Arun District Council
Arun Civic Centre
Maltravers Road
Littlehampton
West Sussex BN17 5LF
Planning & Building Control General Enquiries
Tel: (01903) 737756 Fax: (01903) 730442
Dx: 57406 Littlehampton
Minicom: 01903 732765
e-mail: planning@arun.gov.uk
website: www.arun.gov.uk/planning

Application No: R/227/20/PL
Site Address: Laundry 38 Oakhurst Gardens Rustington Littlehampton BN16 3AN
Description of works: Demolition of existing laundry building, lean to & shed, construction of a ground & first storey accommodation building housing 3 No. sheltered housing flats & construction of a single storey laundry building including upgrade of associated clothes drying area & surrounding landscaping. This site is in CIL Zone 5 (Zero Rated) as sheltered housing.

Thank you for your internet representation made on 22nd December 2020 which has been recorded as an objection with the comments as follows:

Project	Laundry & Accommodation Oakhurst Gardens	Project No.	010
Client	Littlehampton & Rustington Housing Society		
Date		Drawn	ES
Scale / Format	Not to scale	Checked	JT
CAD Reference		Approved	
Drawing Name	Neighbouring Proximities and Views	Drawing No.	010-P-60-01

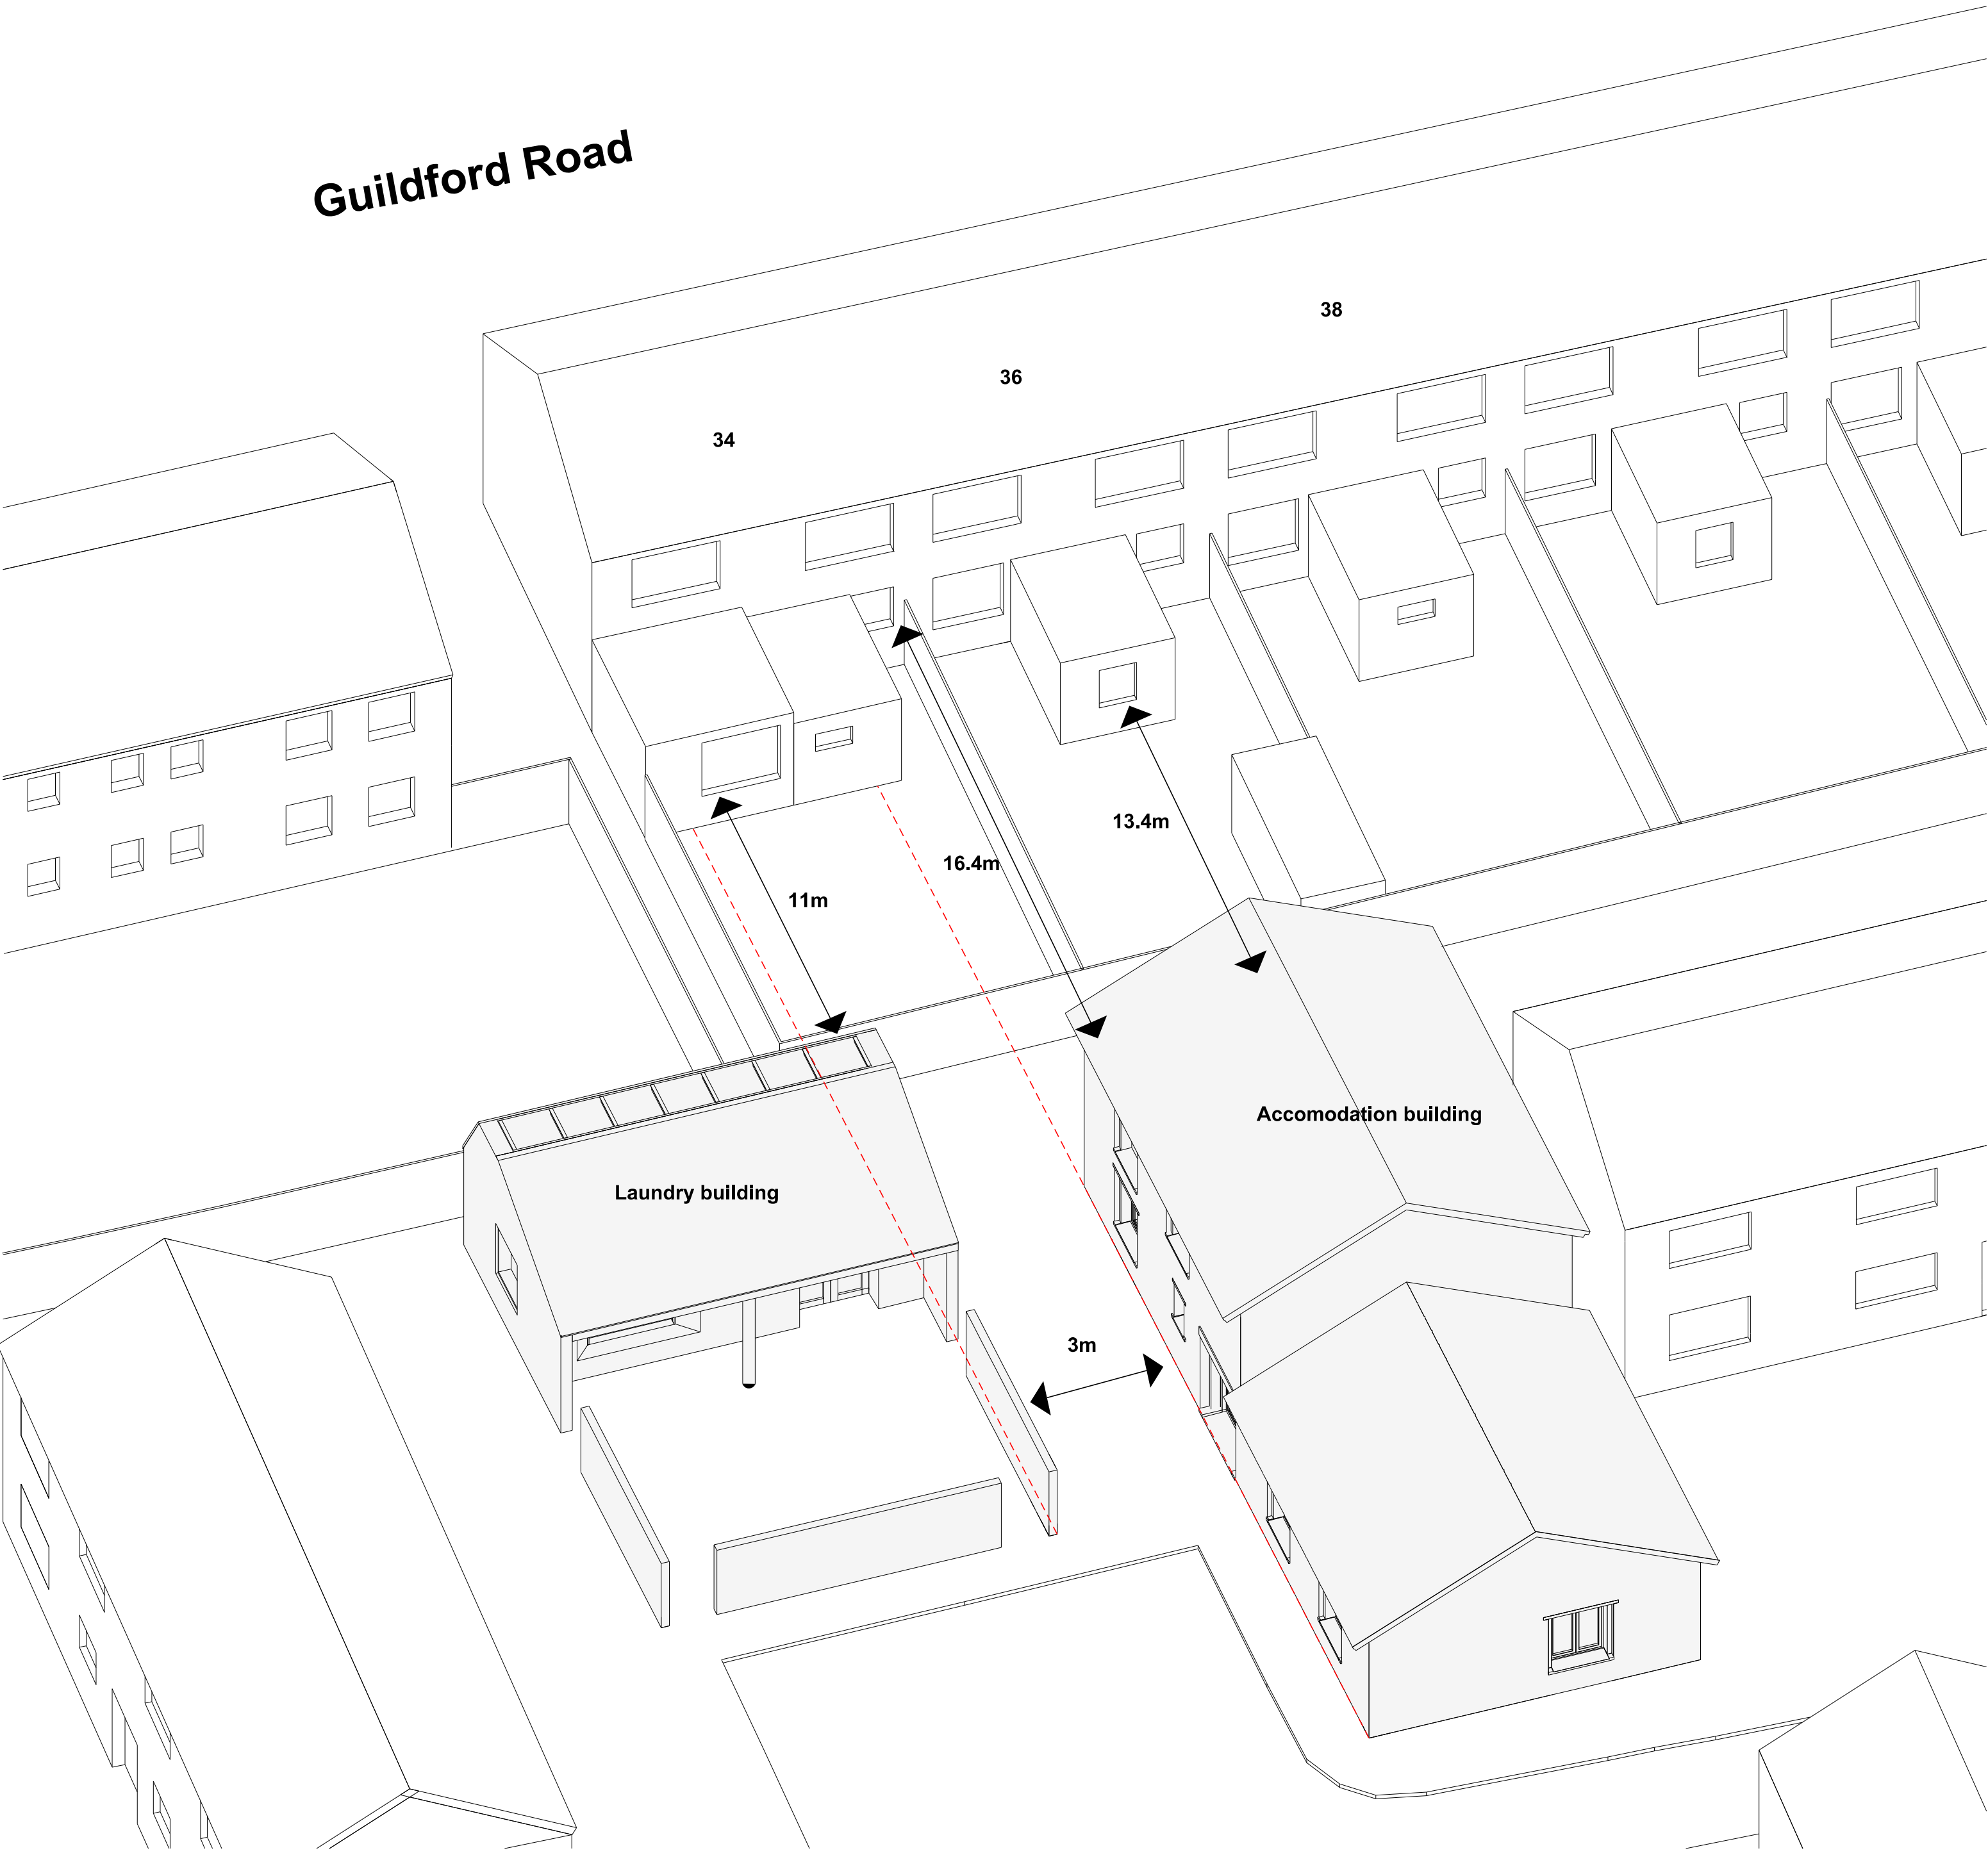
(a) The proposal, by reason of its specific location, height, mass and design, would present an over-bearing and unsympathetic appearance which would have an adverse effect on the visual amenities of the occupiers of Nos. 34 and 36 Guildford Road, and would be severely detrimental to their quiet enjoyment, particularly given its close proximity to the boundaries of these properties
